Please ask for: Ms Iqraa Malik  
Email: [iqraa.malik@terraquest.co.uk](mailto:iqraa.malik@terraquest.co.uk)  
Telephone: 01212341390  
Our Ref: M/51/20/HH  
Your Ref:  
Date: 17th July 2020

**Application for Planning Permission for Works or Extension to a Dwelling**

**Development:** Single storey side extension with flat roof  
**Location:** 53 Ilex Way Middleton-On-Sea PO22 6PN

Location Plan 1:1250

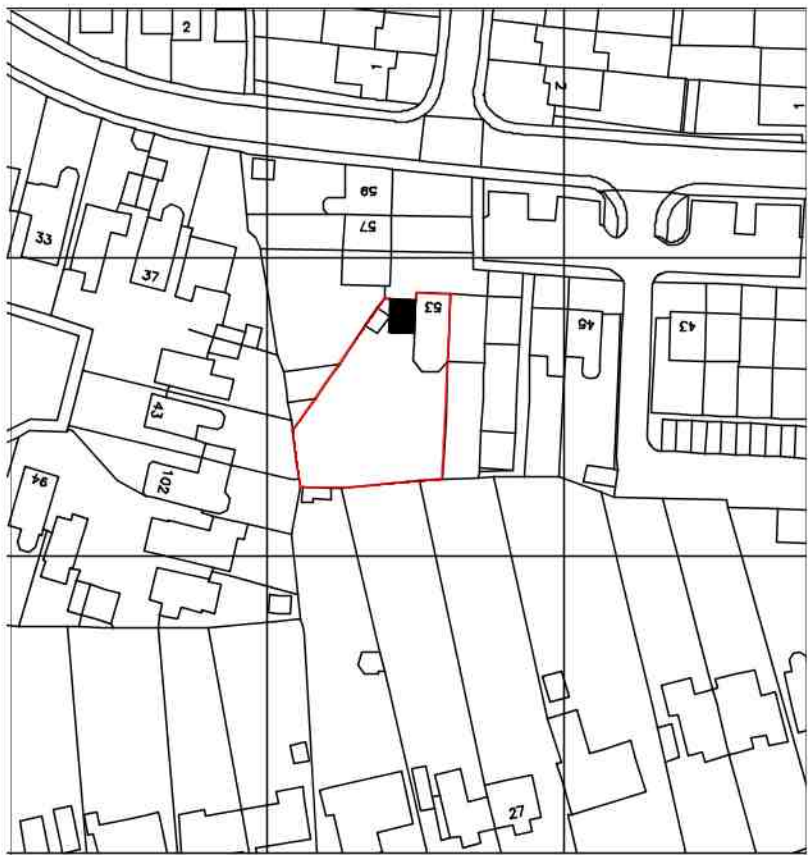
**Location Plan**

The location plan outline is inaccurate. This should be outlining the entire site boundary. Please amend.
